**Application for a non-material amendment following a grant of planning permission.
Town and Country Planning Act 1990**

The consolidation of 15 existing units within the Pavilions shopping centre to create a single,large format retail unit, including reconfiguration works at basement level, insertion of new mezzanine floor and associated works at roof level.

Application for non-material amendment to planning permission 35214/APP/2014/2231

Drawing Title: MSU REDEVELOPMENT PROPOSED FIRST FLOOR PLAN

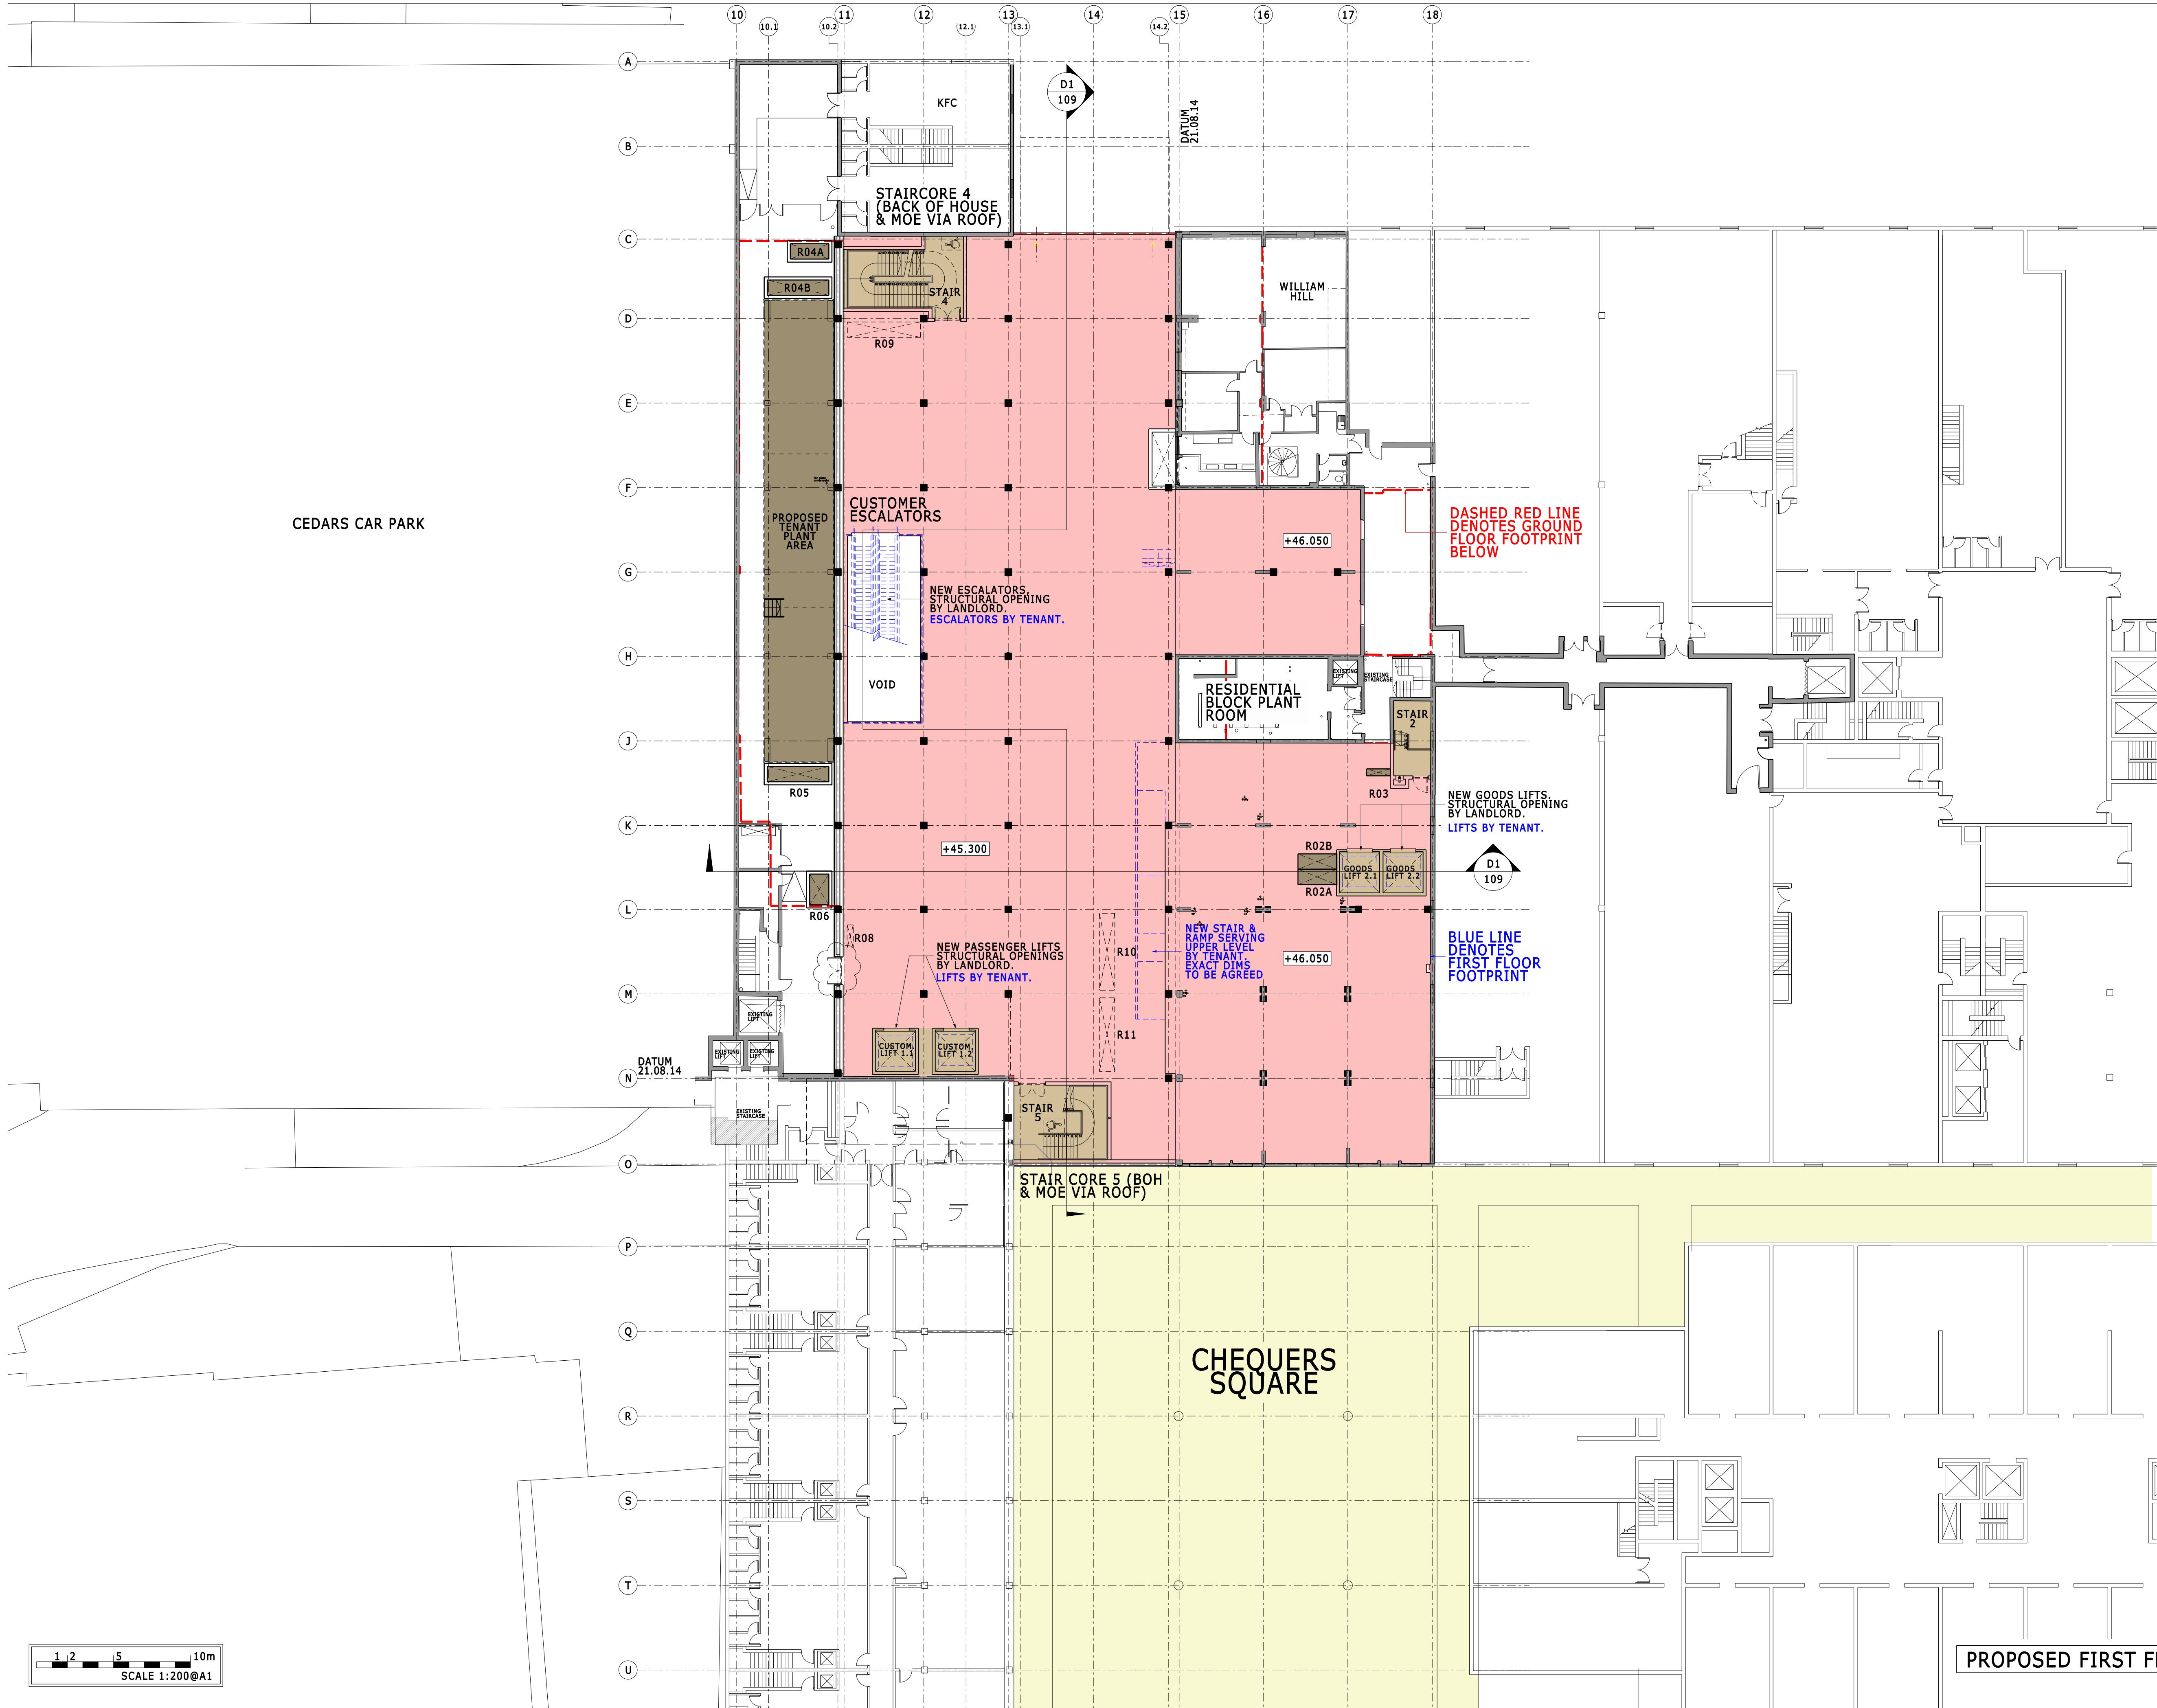
- For the relocation of 2 no. services riser on the new roof.
- For the extension of 1 no. lift, for service/ roof access to Tenant plant area.
- For the provision of a double access service door to replace the single door leaf on Grid Line 11.
